# KIRKLEES METROPOLITAN COUNCIL INVESTMENT & REGENERATION SERVICE

Reference No:	<b>2024/65/90270/W</b>
Site Address:	Queensgate Market, Princess Alexandra Walk, HD1 2UJ
Description:	Listed Building Consent for demolition, alteration, refurbishment and extension to create library, food hall and public realm (part within a Conservation Area)
Recommending Officer:	David Wordsworth

## **Application: 2024/90270**

**Proposal:** Listed Building Consent for demolition, alteration, refurbishment and extension to create library, food hall and public realm (part within a Conservation Area).

6.3.4 West Elevation

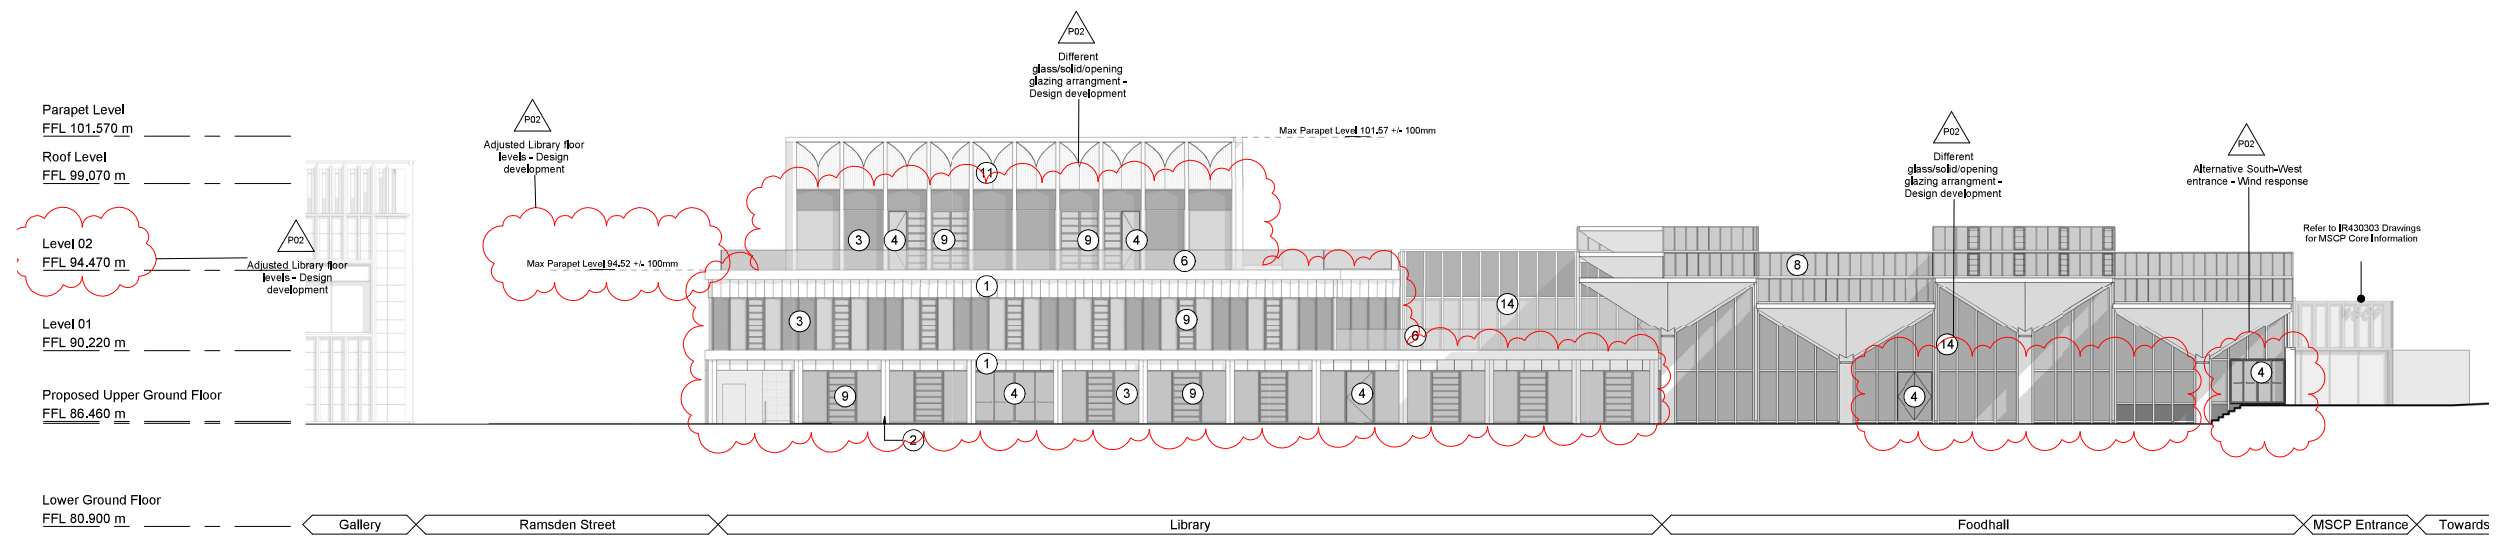
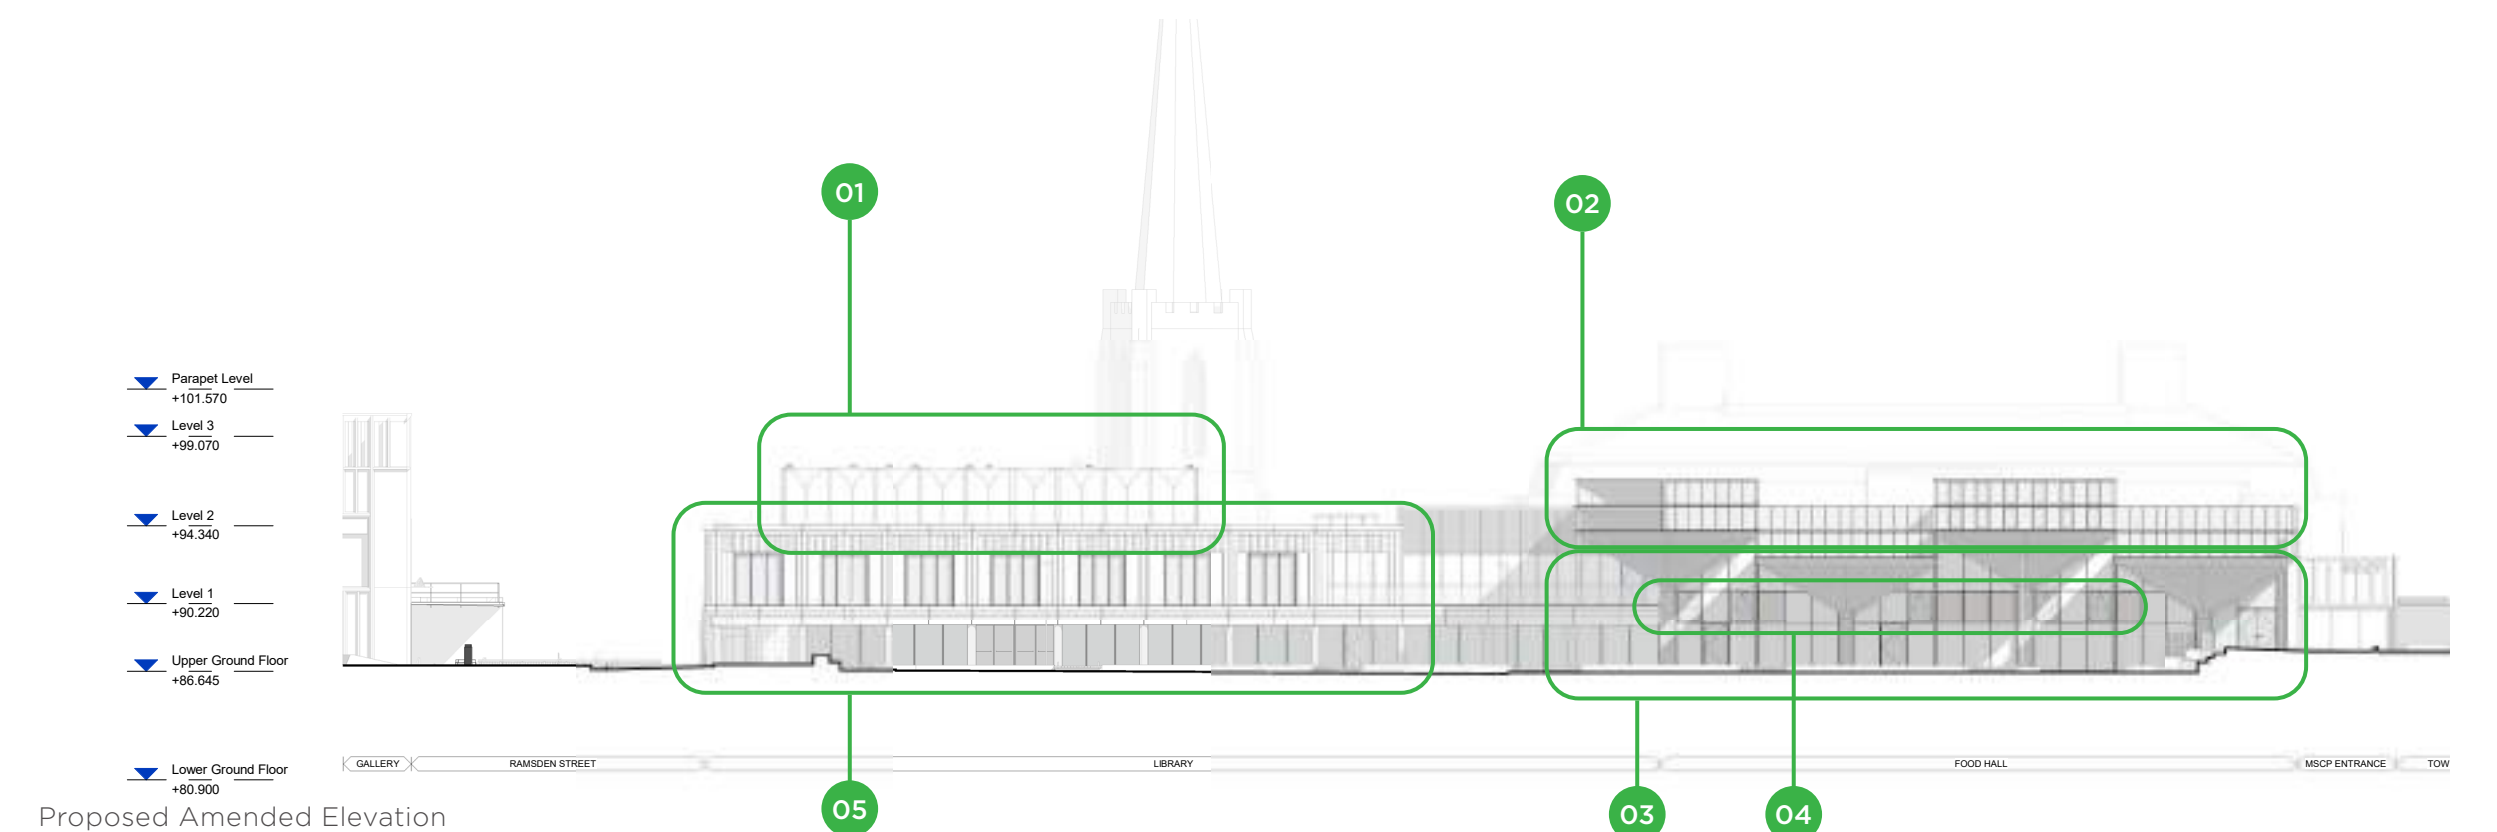
*West elevation:*

A fully glazed west elevation of the food hall was approved and has been amended to a mix of glazing and solid cladding. As this is a new elevation following the approved demolition of the existing west elevation, no historic fabric would be affected by the change. The proposed metal panel cladding replicates the format of the approved glazing modules and would improve the thermal performance of this elevation with no impact on significance, subject to detailing and materials being submitted for approval.
